**Consultation Response from KC,
Trees****2024/92281 Land adj, 17, Whitehall Road West, Birkenshaw, BD11 2LS****Erection of 23 dwellings****Date Responded: 30/10/2024****Responding Officer: JD****Responding Ref: 03/18**

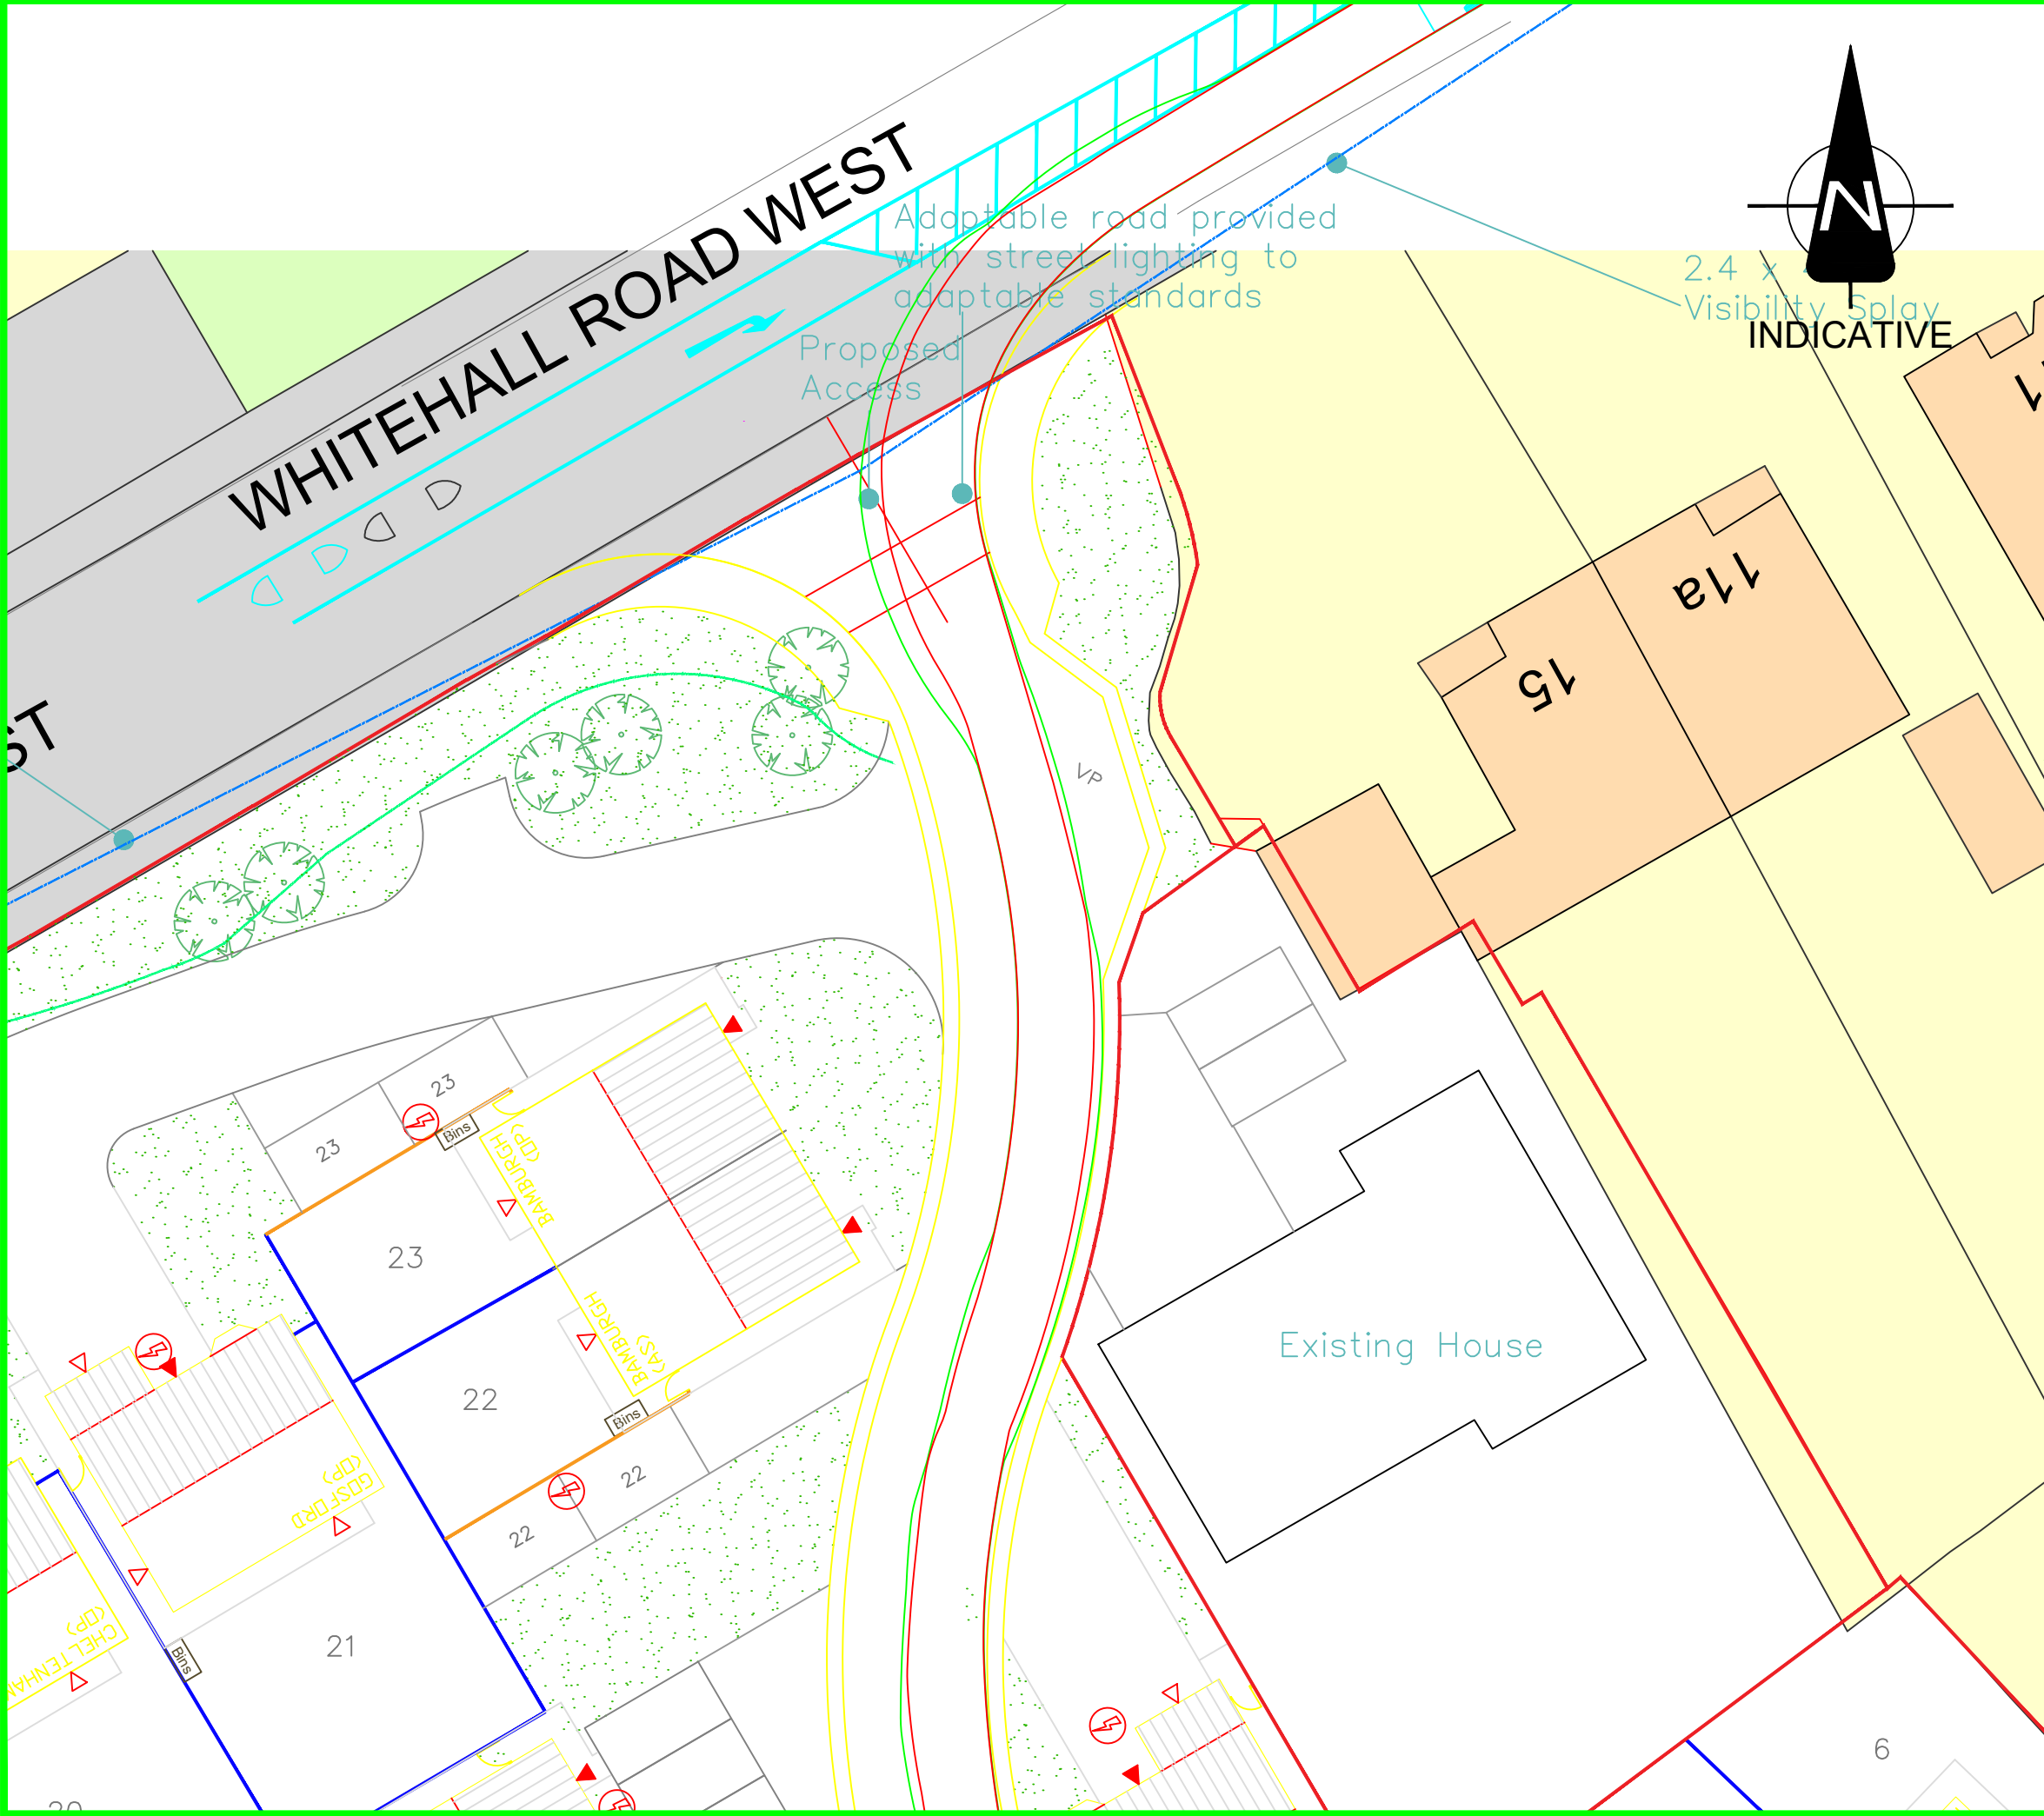
From the plans submitted it is clear that the gardens of plots 7 to 12 will be cast in shade for the majority of the day. This will lead to future pressure to have the protected trees removed which would then mean the entire development would be void of any mature trees and the amenity value they provide.
